GLEBE ROWING CLUB INC.

Your reference: **SSD-8924**

Concept development application for the New Fish Market & Stage 1

**Diagram : Proposed Relocation Of Rowing Route**

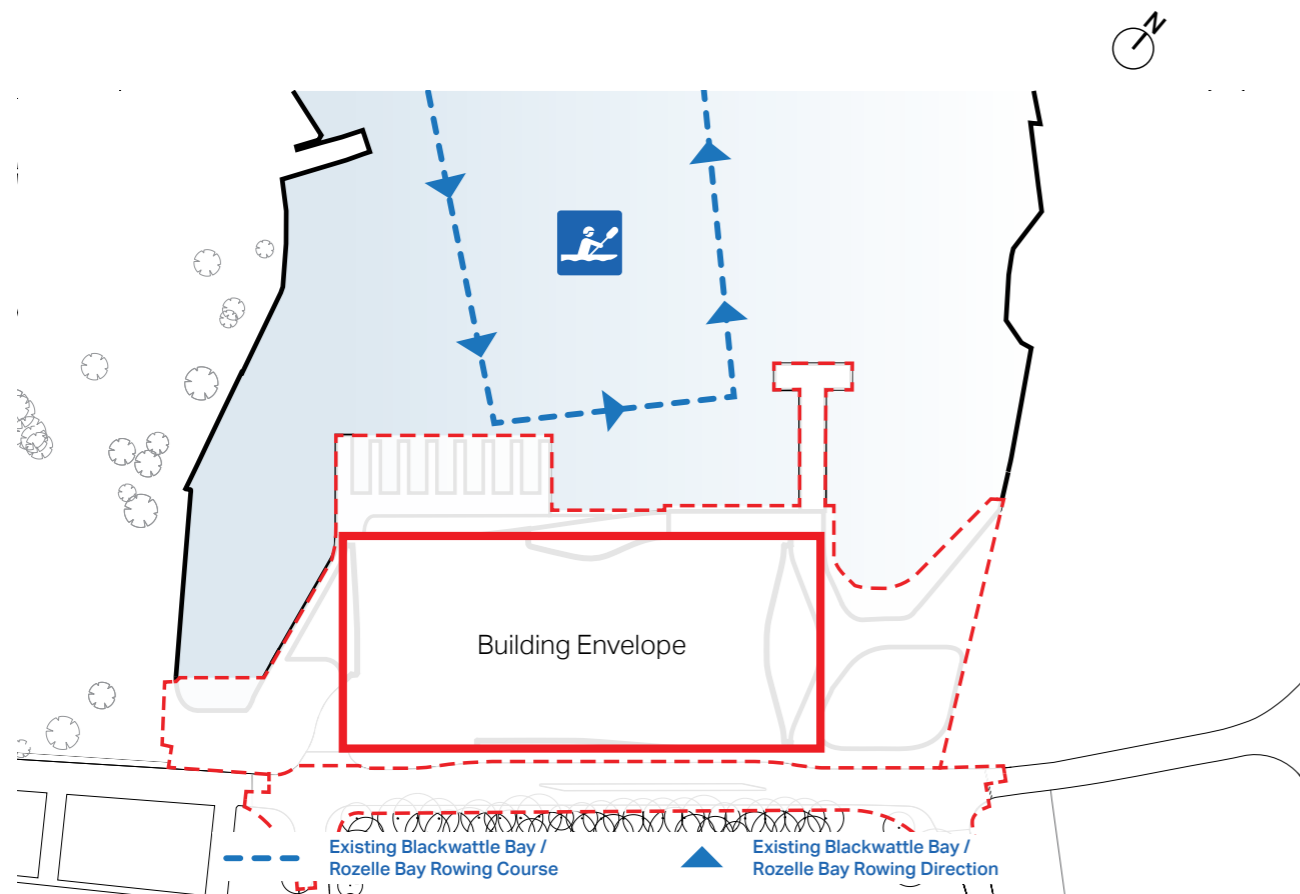
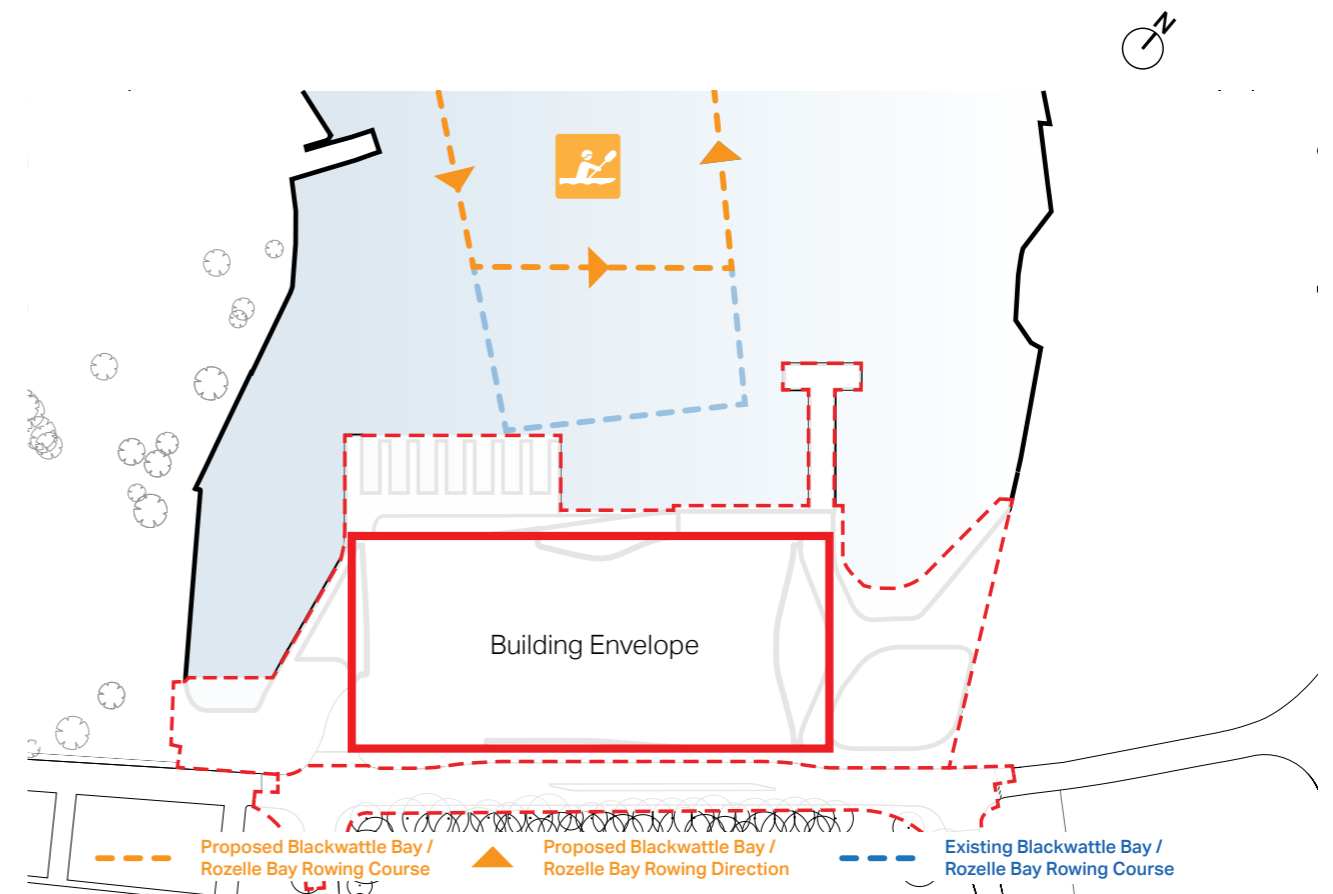
2. The length of the public wharf on the eastern side needs to be shortened by 32m to ensure it does not create an unsafe turning circle for recreational water traffic.

The current design includes an Eastern public wharf designed to accommodate motorised recreational vessels and a ferry stop. The proposed wharf structure extends an additional 65 metres into Blackwattle Bay and it is proposed that the current agreed rowing course be shortened by 45 metres to accommodate for the new wharf.

We currently muster and turn where the Eastern Wharf is planned to end. Even with a reduced rowing route, we estimate that our turning circle would put us directly in front of the new wharf. When including ferry services likely to be placed at the front of the wharf, rowing boats would be mustering around 20m from the wharf. By the NIP's own account, this is an unsafe distance from the Eastern Wharf.

The current analysis of the safety of the planned Eastern Wharf does not reflect: a) correct rowing route and lanes; b) the turning circle of rowing boats at the head of the Bay; or c) the turning circle of the proposed ferry at the end of the pontoon.

To accommodate for the Eastern Wharf's encroachment onto the Bay, the EIS, and the supporting Navigational Impact Plan propose a solution to modify the rowing route by 45 metres to maintain a safe distance between turning boats and vessels docking at the wharf.

In fact, with the Eastern wharf situated as per the design, to maintain a safe distance would require a 70 metre reduction in the rowing course that would be inconvenient and unsafe. This because the NIP:

- incorrectly identifies the correct rowing course length and direction (see Diagrams A and B); and
- fails to factor in the turning circle considerations of rowing and ferry vessels.

The proposed rowing course identified in the NIP is unsafe as it would put rowing boats on course for collision with on-coming traffic as it places:

- rowing boats travelling on the Eastern side, essentially down the middle of the Bay, typically in the same lane as an increased number of motorised craft that typically travel down the middle of the Bay; and
- would have rowing boats leaving the pontoon at right angles to rowing craft coming down the West side of the Bay.

We request that the wharf be shortened by at least 32m to restore the safe distance from the actual turning circle of boats and the wharf.

To maintain the safety considerations accounted for within the design of the current rowing course, the length of the proposed East Side wharf needs to be reduced by approximately 32 metres. This is required to maintain a safe distance from turning rowing boats from the ferry wharf.

**Diagram : Wharf - Recreational And Ferry**

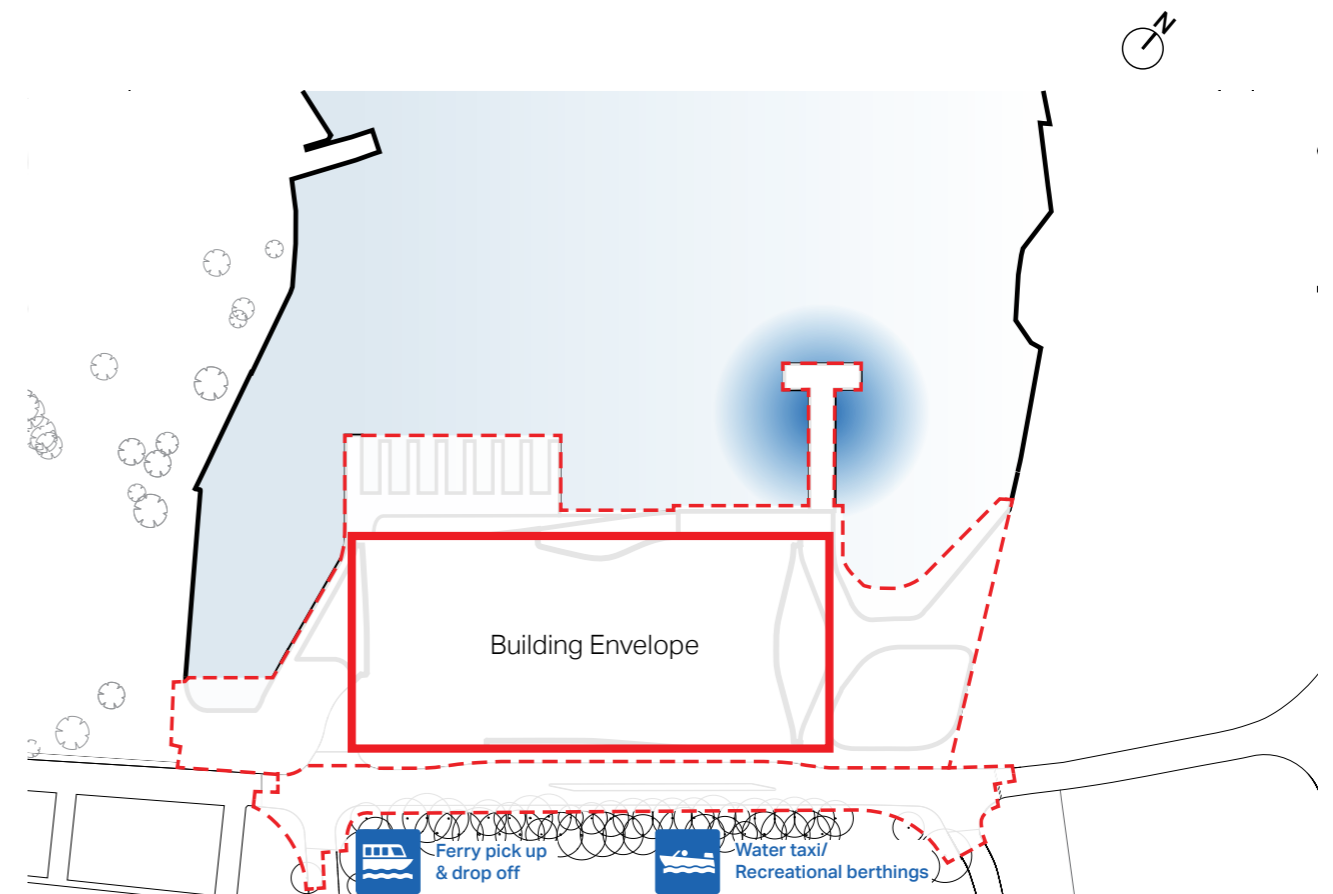
- *Lack of justification for the number of pleasure craft docking berths, size and positioning of the East wharf.* The EIS cites 'day trippers' to the fish market would arrive by boat. Currently, small powered vessels only occasionally arrive for a few minutes to pick up food orders before departing. Whilst it is acknowledged that this is projected to increase with the redevelopment, the submission lacks data on projected numbers that would justify the number of pleasure craft docking berths planned. Similarly, the Eastern wharf includes ferry docking, however, there seems to be no analysis undertaken to indicate the extent of any ferry services.
